Topic Header	Issue number	Page number (officer's report – 2022/92169) or original pre-application response	Issue	Action to Resolve
Pre-app advice not taken on board	1	4	Officers would also note that pre-application advice has been provided in relation to residential development at the site, but it appears that the advice provided by Officers has not been adequately taken on board.	All issues raised in the officer's report and <i>previous</i> ++ pre-app response have been addressed within this document. ++ i.e. in connection with previous unsuccessful proposals.
Green Belt	2	9	Two storey side extension to the gable end of the attached barn does not appear as a proportionate addition to the barn. (Contrary to national / local policy).	The proposed two storey extension has been retained for the architectural reasons set out at Point 11 below. It has been reduced in depth and width to take on board previous comments. When considered as an extension to the attached and detached barns (because they will be linked), the extensions are not disproportionate to the original structures: Volume existing attached and detached barns: 497 + 218 = 715 cu.m. Volume of extensions: 270 cu.m $270/715

title General Arrangement as Proposed
number 23038D-02-P04
scale 1:100 or as shown
size A1

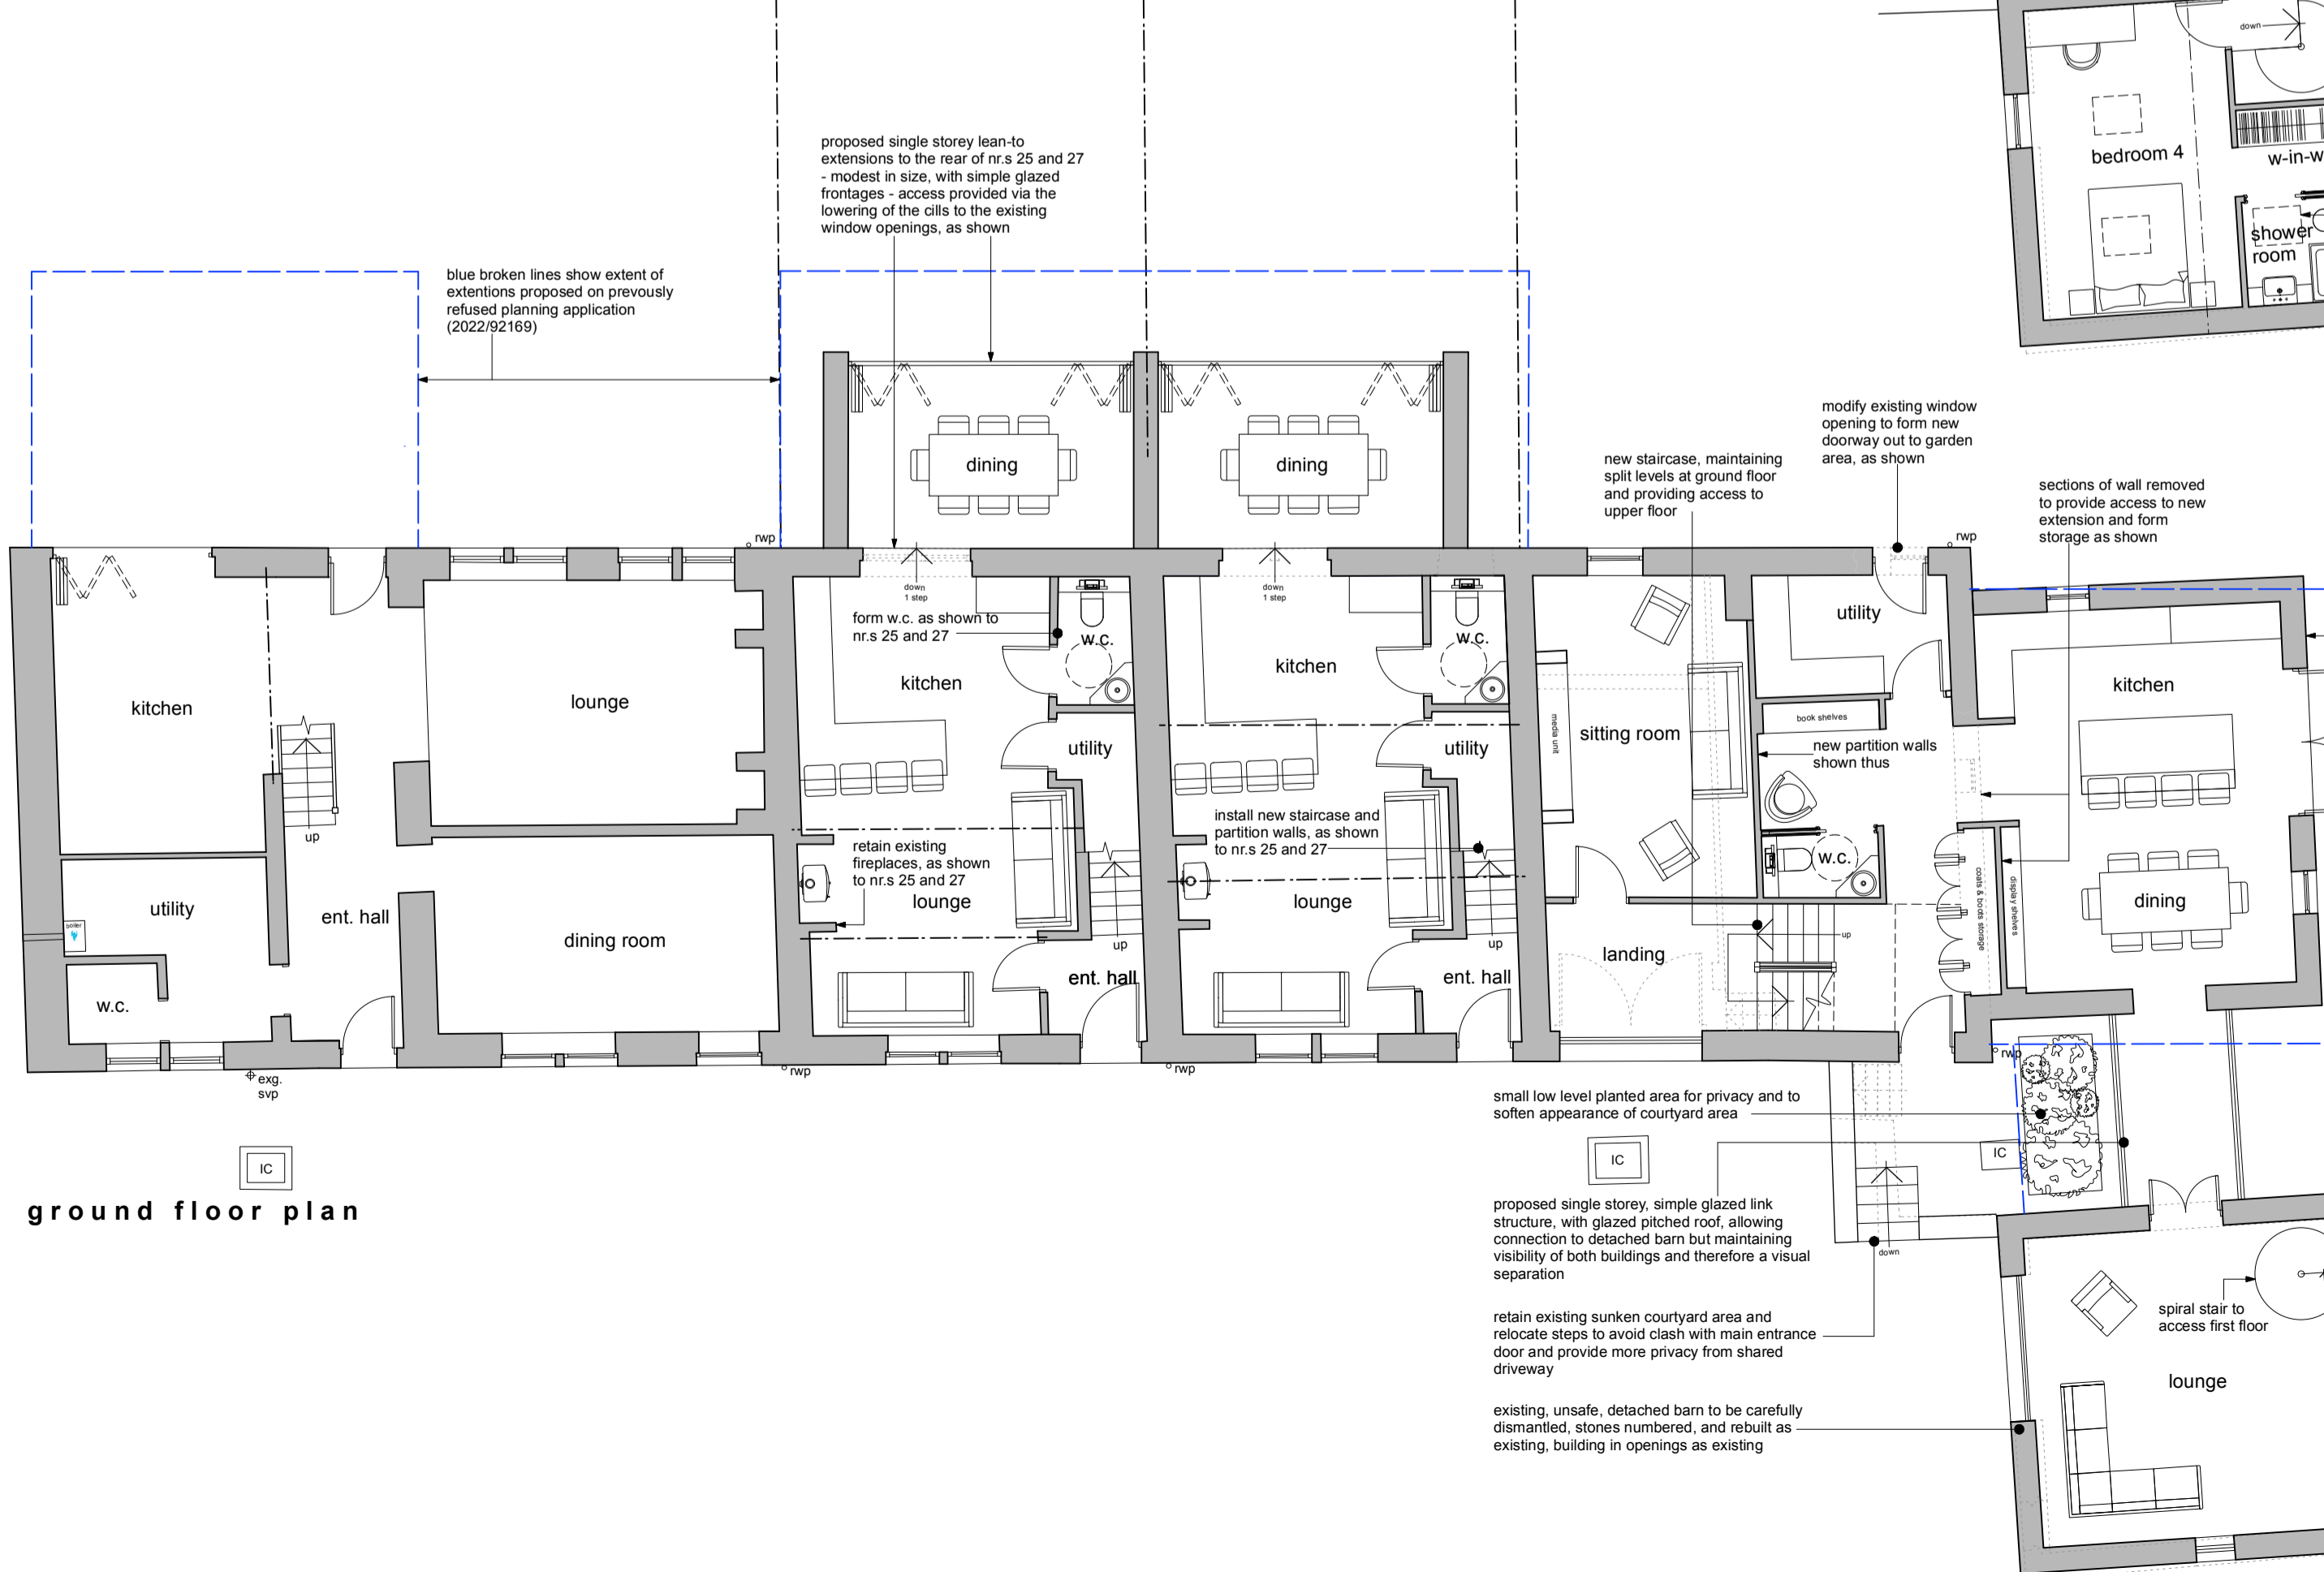
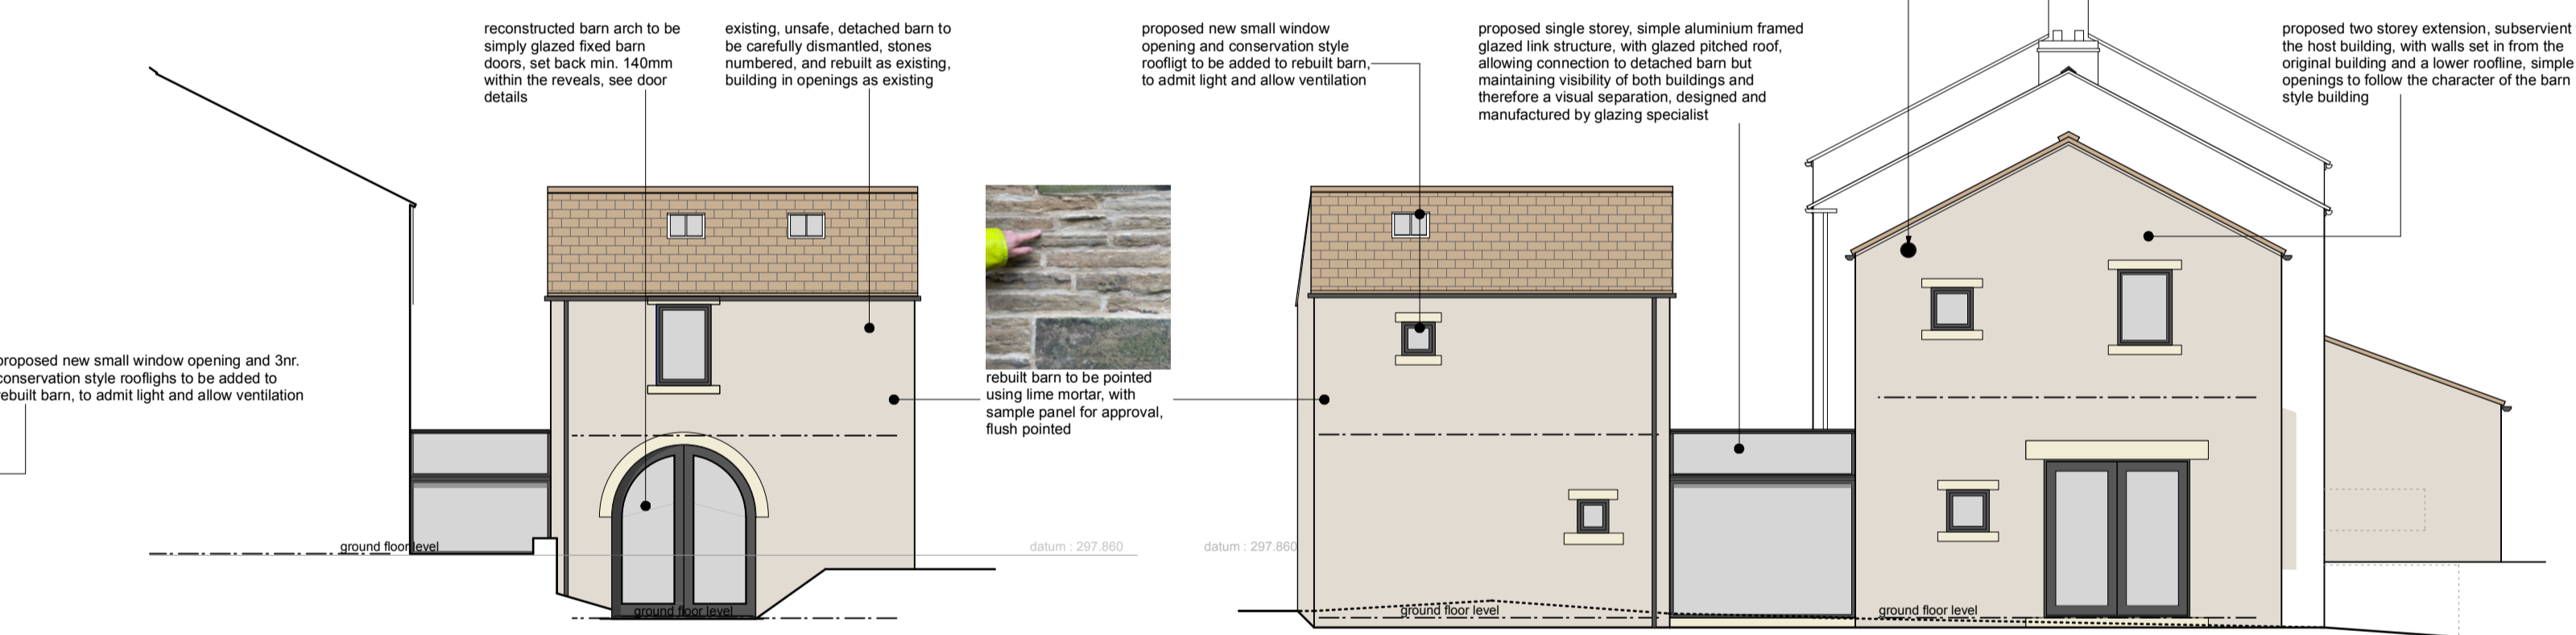
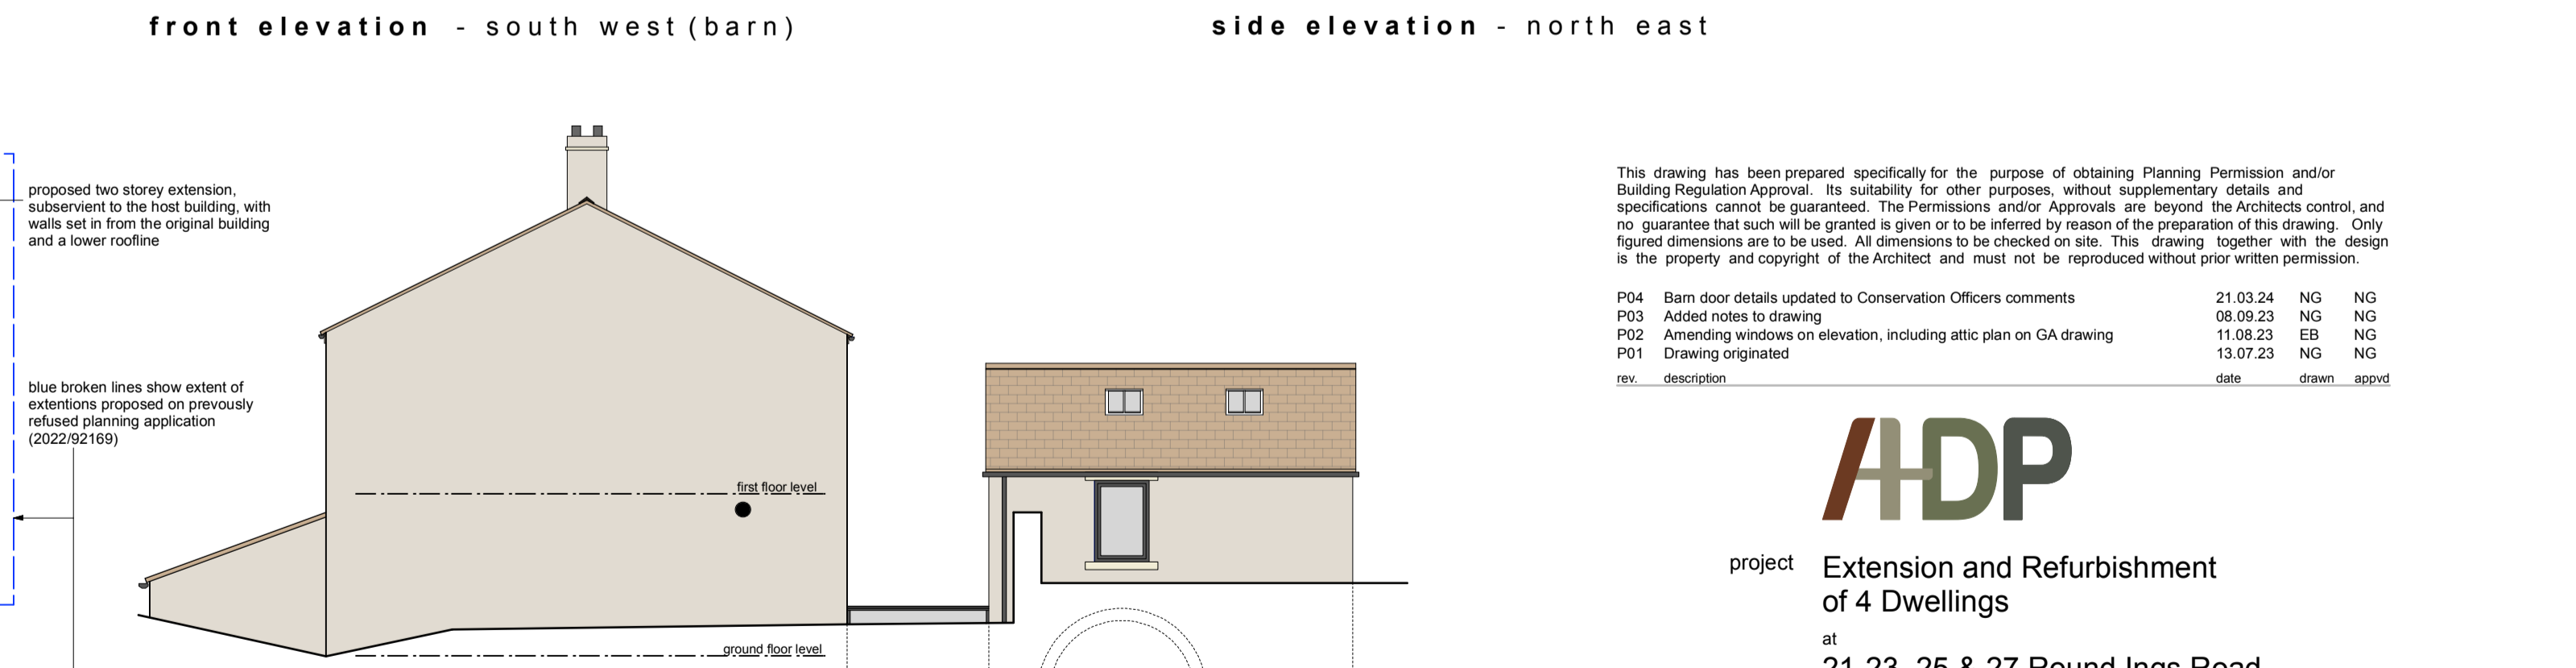
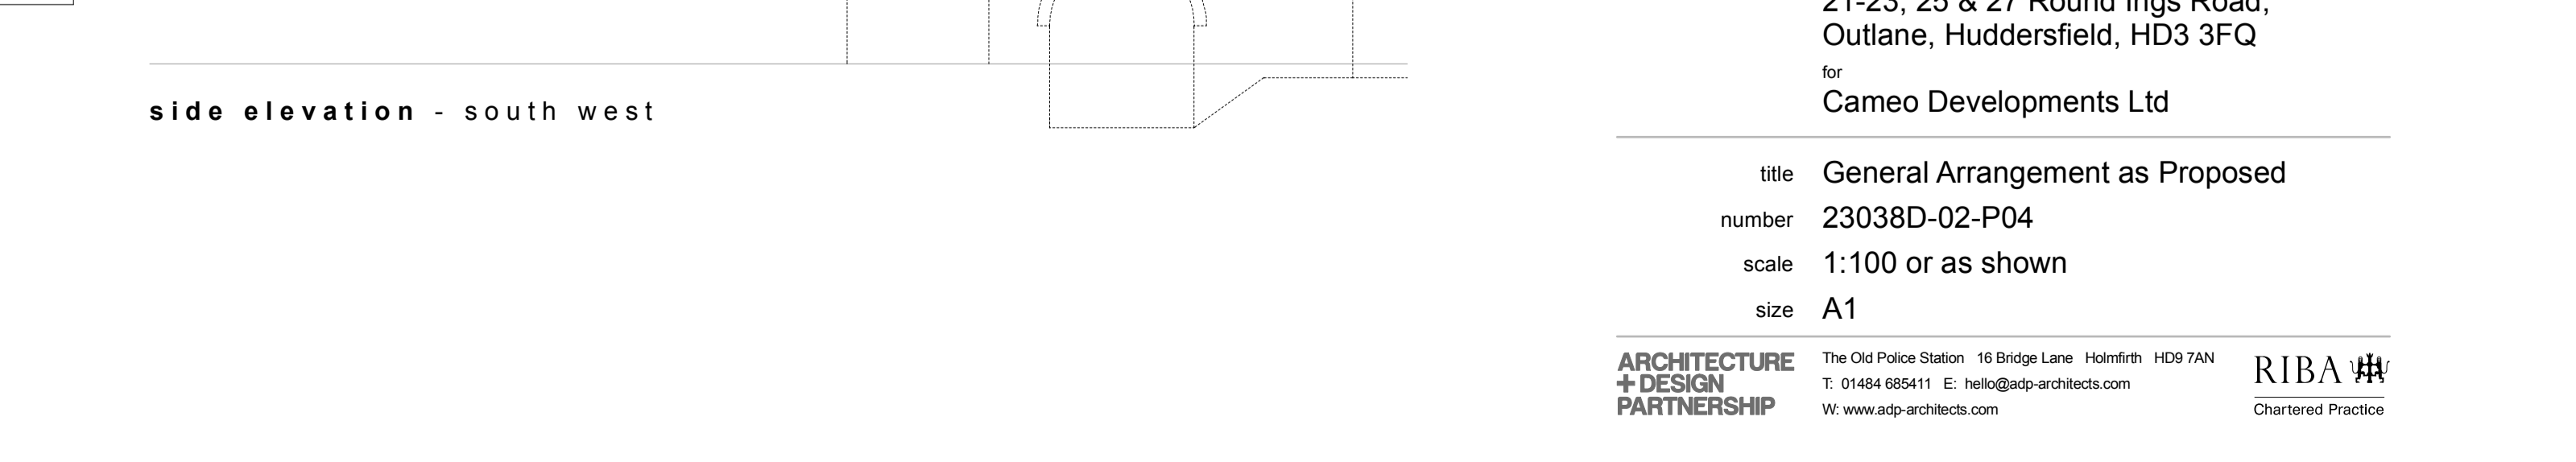
Heritage	11	15/16	Barn Conversion “A two-storey extension is proposed to the east gable of the attached barn (dwelling no. 4 as proposed). This structure is set back slightly from the front and rear walls and is set below the ridgeline of the existing building. Although set back and lower down, this structure is a substantial addition to the terrace, as it would be the same width as the existing barn, leading to confusion and resulting in the loss of definition of the historic terrace and barn..... The window configuration of the proposed extension is overly domestic too, with incorrect detailing for the context, thereby causing further harm to the significance of the listed building..... The window configuration of the proposed extension is overly domestic too, with incorrect detailing for the context, thereby	Redesigned barn conversion now proposed – smaller extension (shorter and lower), simple, smaller glass link to detached barn, and proposed more “barn-like” style openings to retain agricultural character. Keeping glazing to barn arches as simple clear glass screens, with no divisions The option of a single storey extension has been carefully considered however the architect Natalie Garside has offered her professional opinion: “My view is that a singled storey monopitch extension would be architecturally the wrong thing to do on this end of the barn. The previous scheme had an extension which was slightly longer than the existing barn and the LPA said it

Topic Header	Issue number	Page number (officer's report – 2022/92169) or original pre-application response	Issue	Action to Resolve
			causing further harm to the significance of the listed building.”	<p>caused confusion as to which was the extension. As such, we have shortened this so that it is subservient to the host. The proposed extension is now definitely subservient by being lower, narrower and shorter than the existing barn. The fenestration is also more in keeping. If this was single storey it would make the link to the detached barn much more complex to achieve (roof connections) and I am keen to keep this very simple, small, and fully glazed and therefore transparent and unintrusive.”</p> <p>Overall, we consider that the reduced scale and improved design of the extension means it is now in keeping with the original character and appearance of the barn.</p>
Heritage	12	16	The link building partially obscures the front elevation of the barn and is too large for its context.	Link significantly reduced to a simple glazed link as per drawings.
